Department of Transportation

September 19, 2019

SH83/Walker Rd
El Paso County

re: Monument Academy/YMCA_SH83Walker - Aug2019_Site Development Plan - EA18206_PPR199

WALKER ROAD PLAN & PROFILE

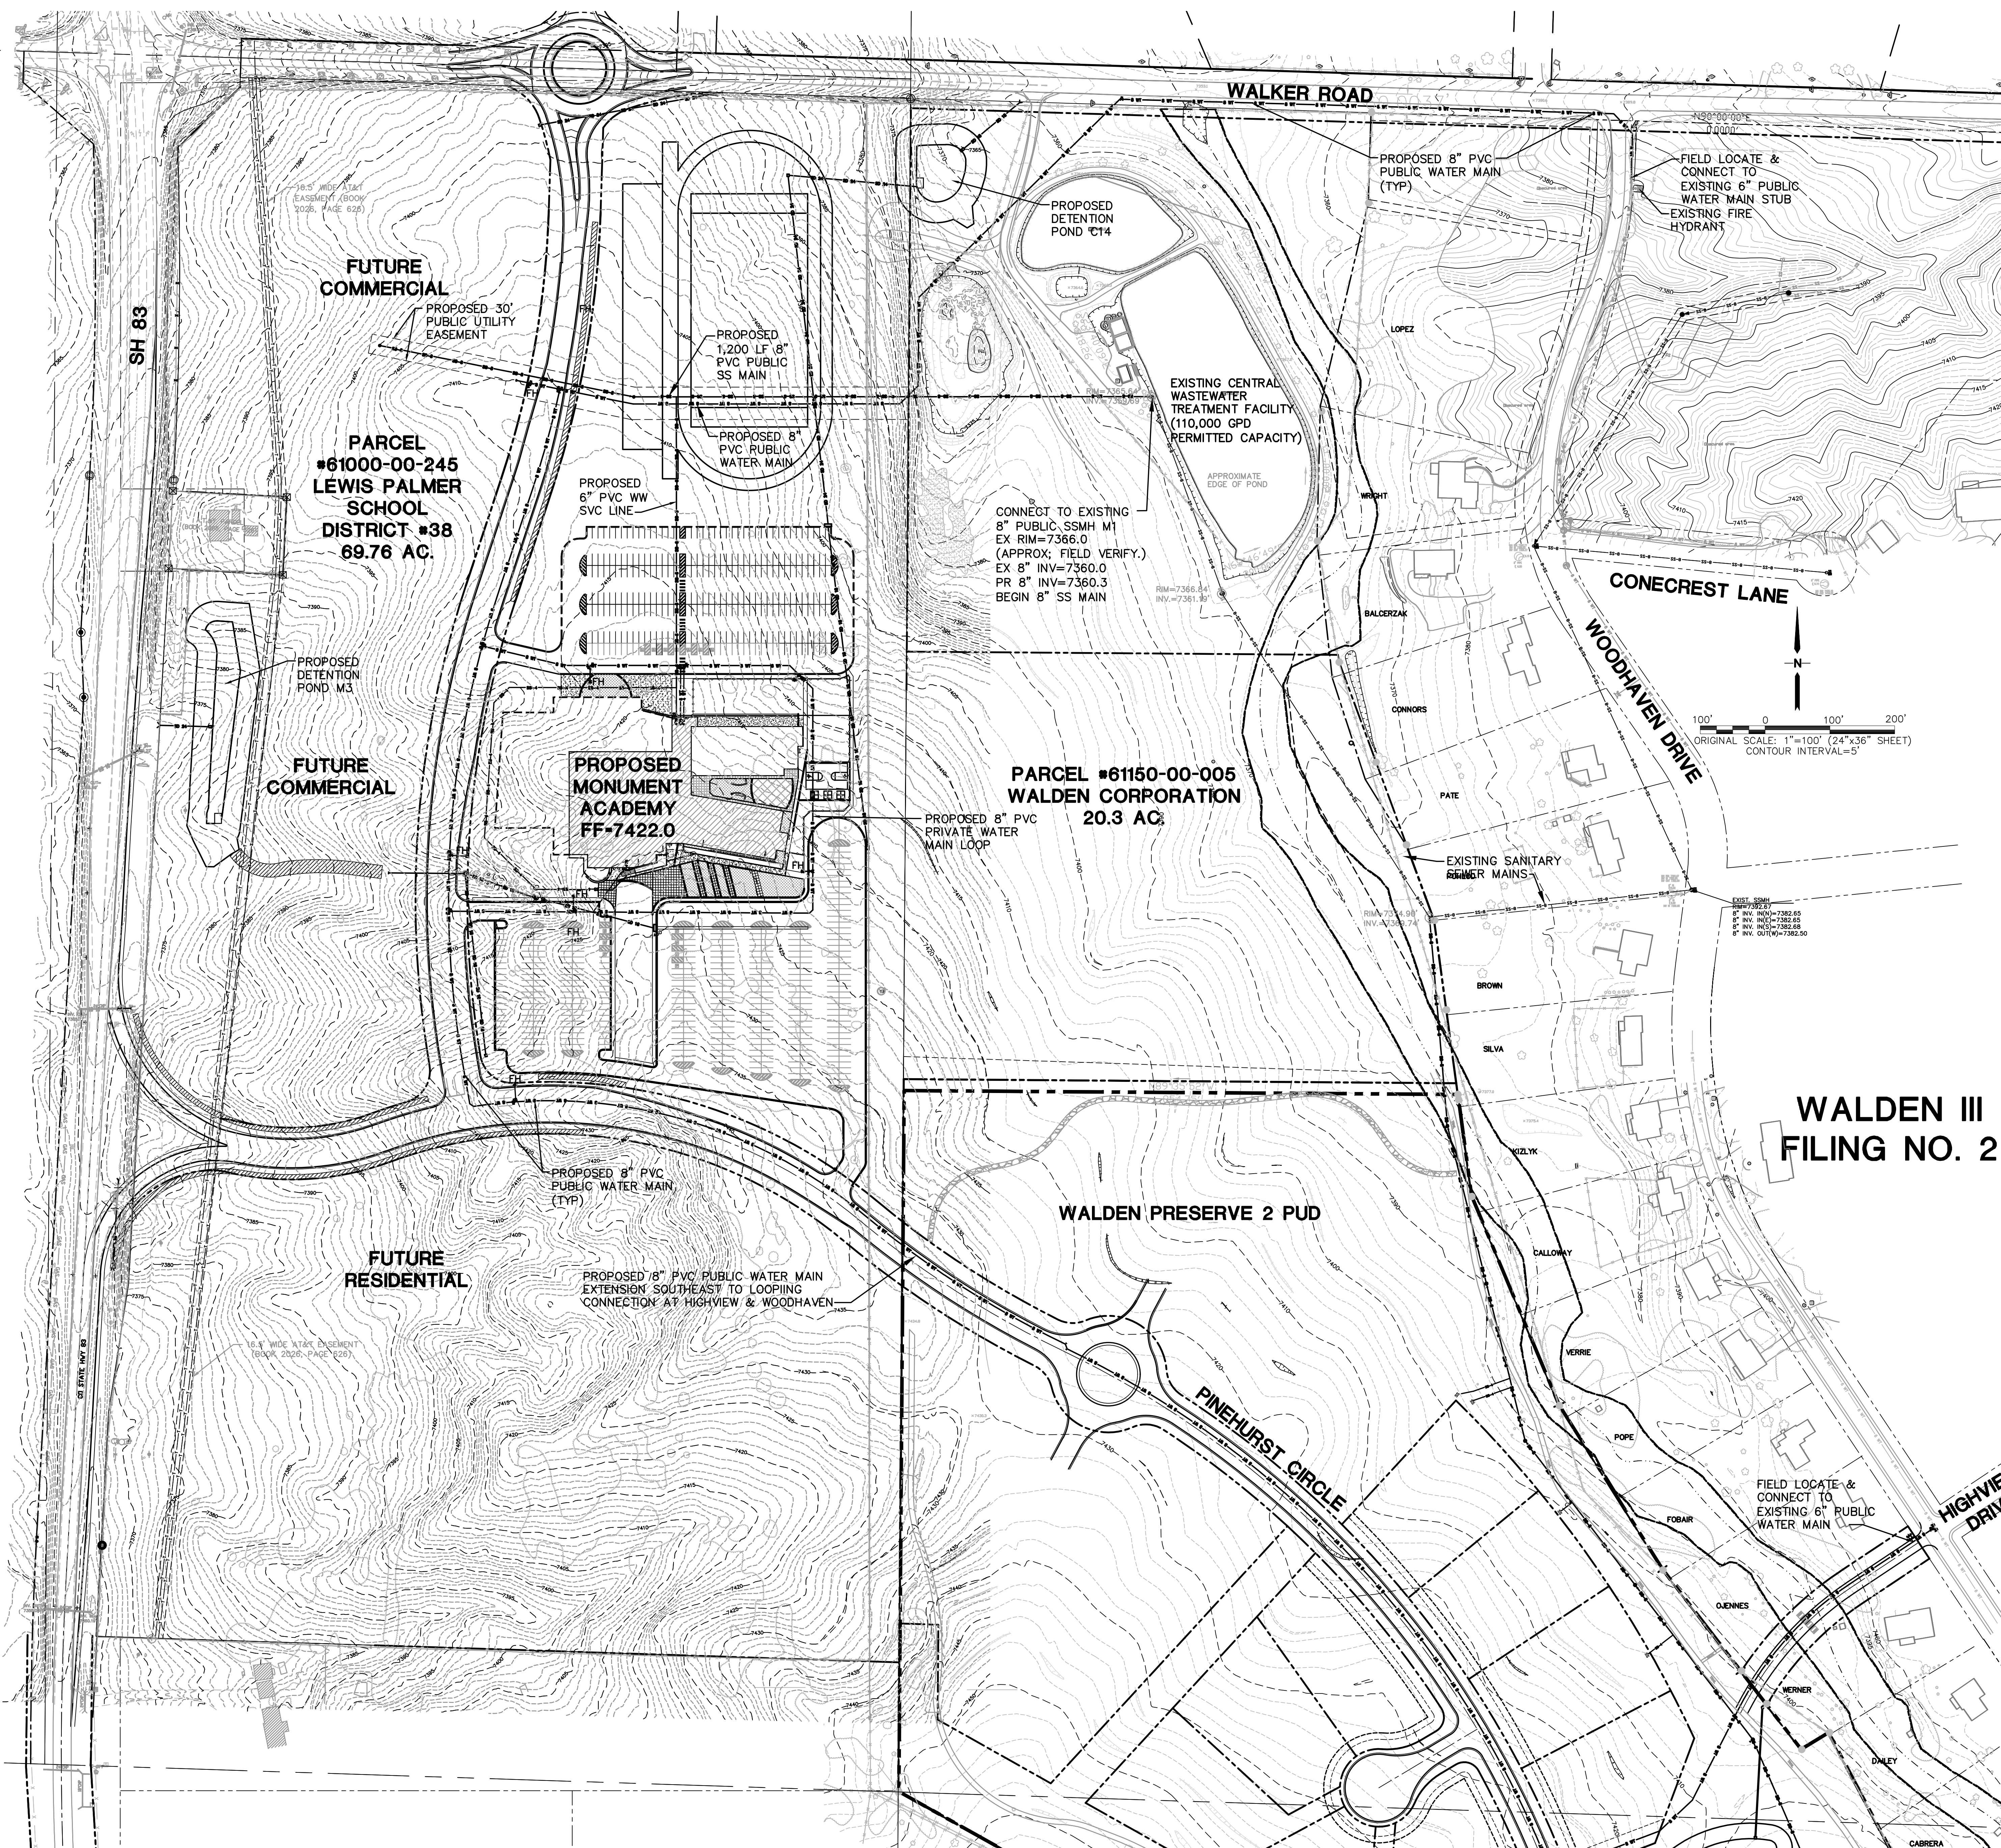
- j. **Walker Rd/Road A connection:** Request for access is being proposed to make connection to Walker Rd., an EPC controlled roadway. The site plan shows connection to Walker Rd. via a newly proposed roadway, "Road A" with a "T" intersection. CDOT supports EPC with the roundabout option to be installed in phase I.

- k. Special consideration will need to be given in the design of the Walker Rd. and Road A intersection for the allowance of the re-alignment of Shannon Rd.

PROPOSED DETENTION POND M3 PLAN

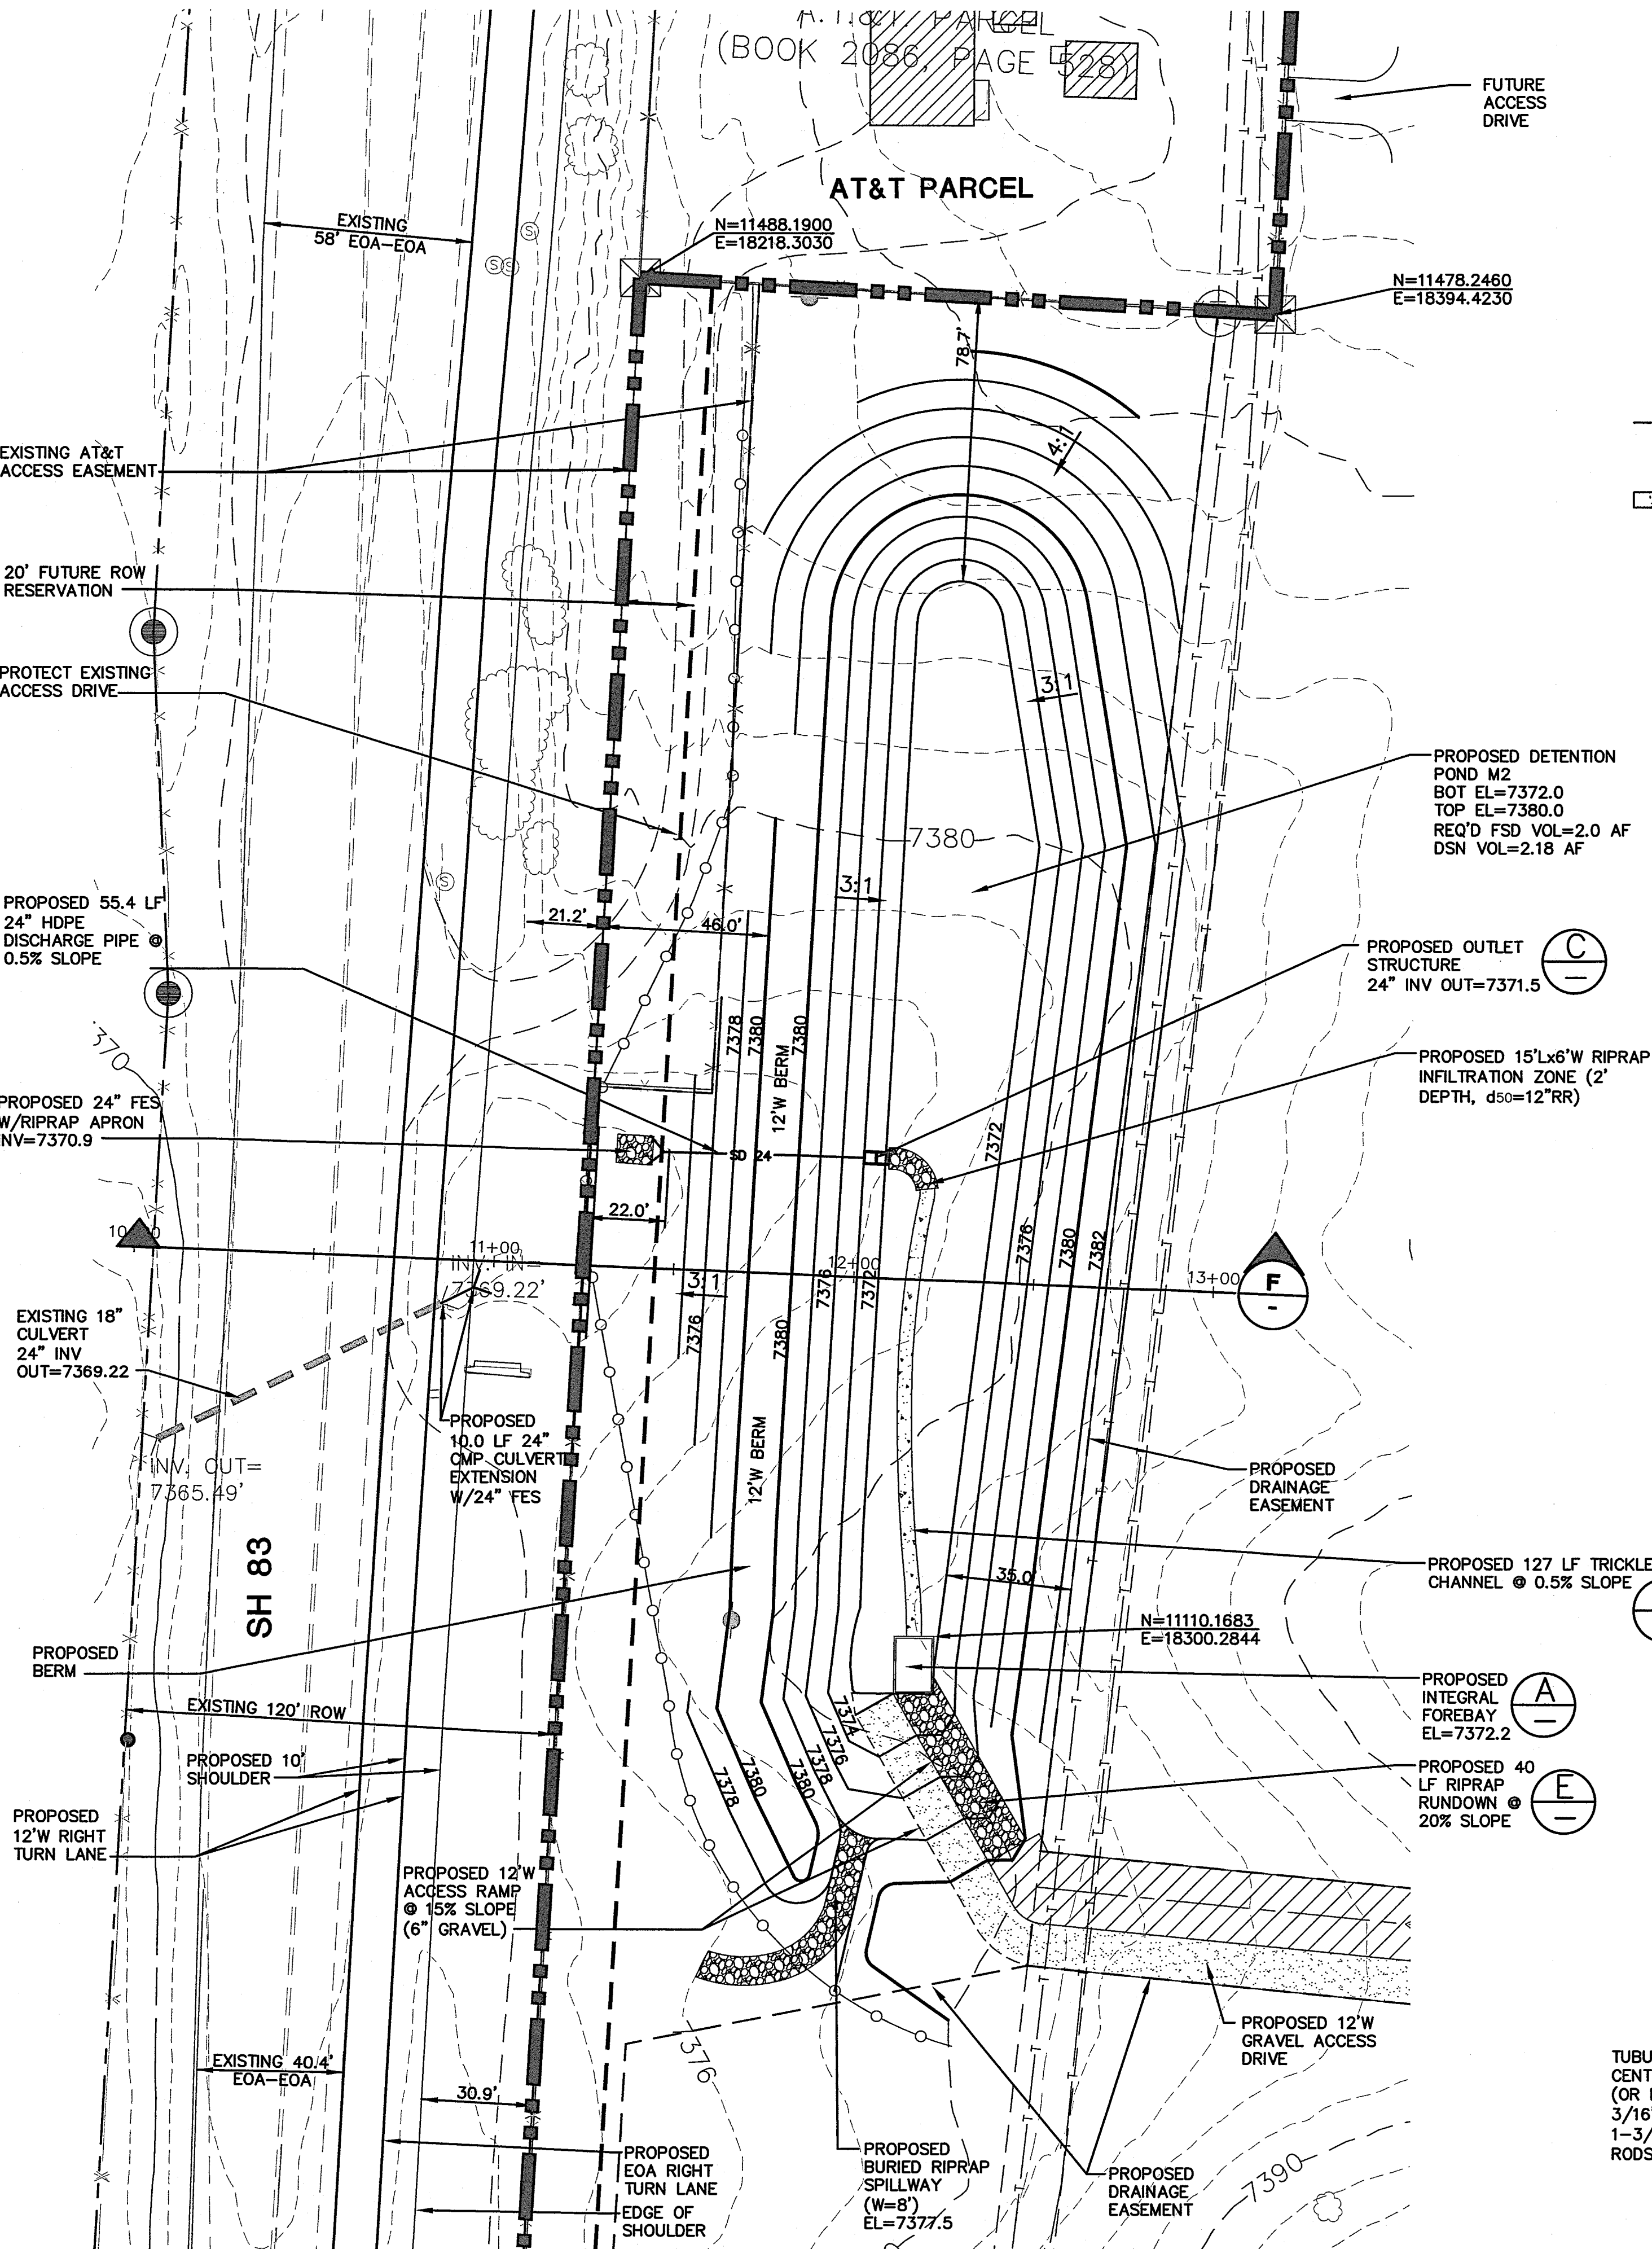
- a. Comments are from the review of Master Development Drainage Plan & Final Drainage Report, dated February 8, 2019 (Revised April 30, 2019), prepared by JSP Engineering.
- b. Drainage Report/Grading Plans, Discrepancy in culvert size under US 83 between drainage report and grading and erosion plan. Please verify size. Drainage plans show as 24" and pond sheet in grading plan shows 18".
- c. Drainage Report/Grading Plan, Pond M3 - Pond spillway elevation given on pond sheet, but grading does not reflect spillway. At the height shown, this pond exceeds 10' in height and could be classified as a jurisdictional dam. Please show grading of spillway to avoid this.

Also, please provide detail of spillway and material used. Use of UDFCD spillway design guidance recommended.

- d. Drainage Report, understanding that Pond M3 is designed to discharge at historic rates, please confirm the culvert crossing US 83 is sized properly to handle flows from the pond outlet along with the additional flows from the roadside ditches.
- e. Drainage Report, Forebay size required = .011 ac-ft., size provided in UD-BMP spreadsheet = 0.005, reviewer calculated = .007. Please increase forebay size to meet minimum required.
- f. Grading and Erosion Plan, show grading of channel that drains to Pond M3 (channel M2.3A).
